Application for a non-material amendment following a grant of planning permission.

| <input type="text" value="16/00058/FUL Conversion and alterations to detached outbuilding to form self-contained residential accommodation for ancillary use Outbuilding At Pogan Hall Picklescott Shrewsbury Church Stretton Shropshire SY6 6NS"/> | |
| Reference number: | <input type="text" value="16/00058/FUL"/> |

Change from low pitch roof on lean-to, to dual pitch roof in tile to match existing barn range

Barn as proposed  
*SKETCH 1:100 @ A3*

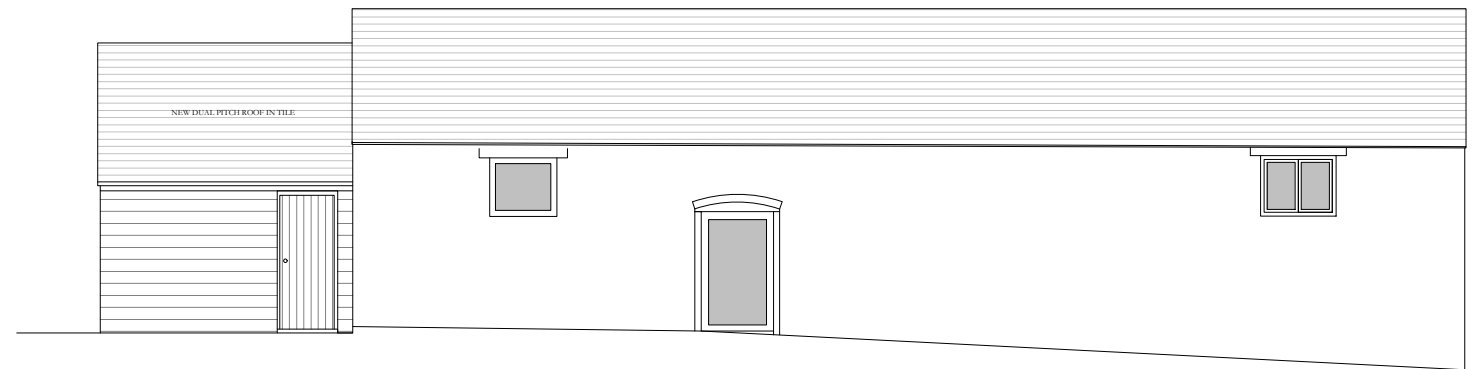
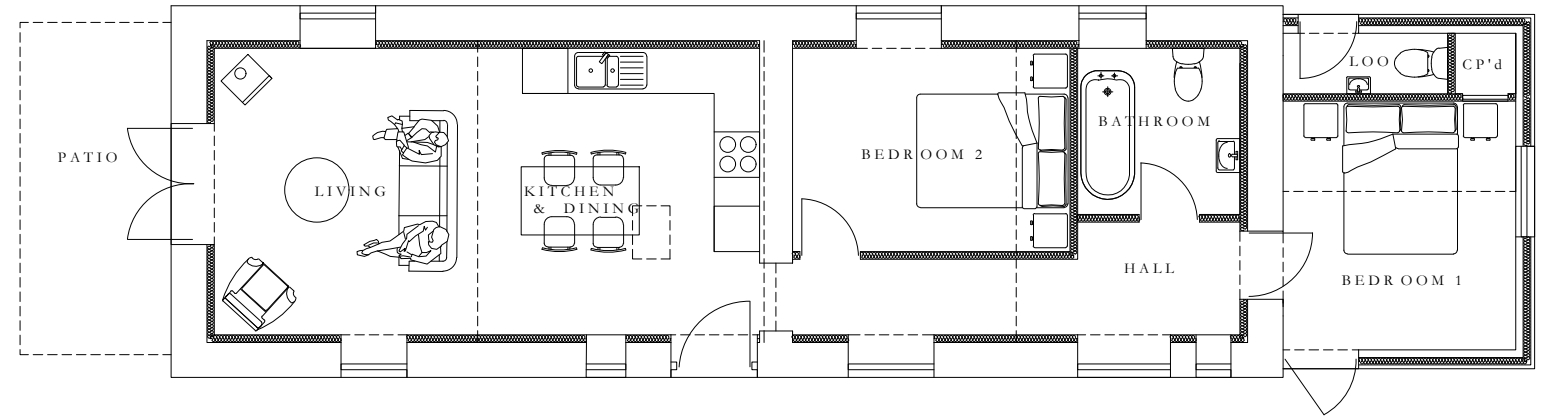
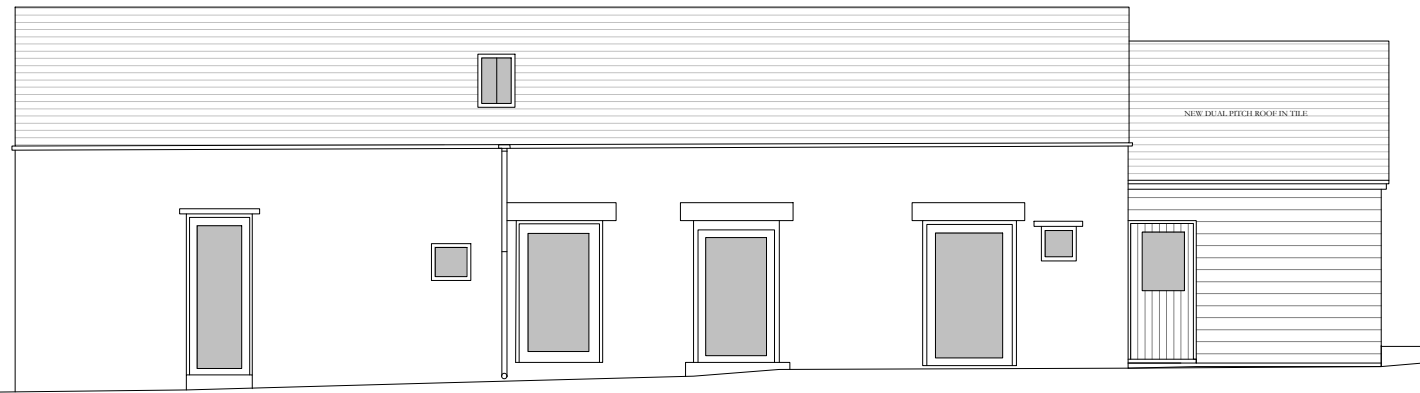
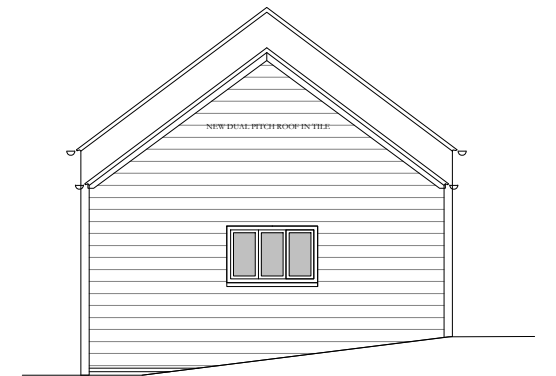
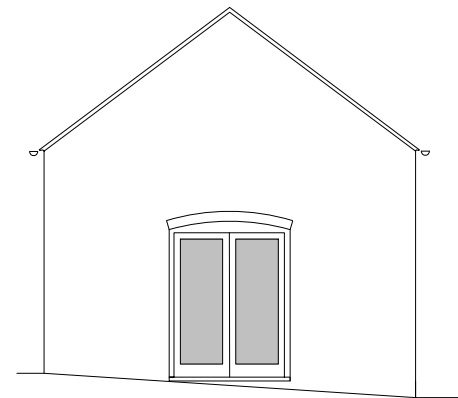
Current lean-to roof too low in pitch to accomodate natural slate or clay tile (the two materials present on adjacent buildings) and internal space heavily compromised; permission therefore sought for adjustment to simialry vernacular dual pitch roof in tile to match barn - albeit at lower eaves and ridge height.

Barn drawings as proposed (Nov 2021)
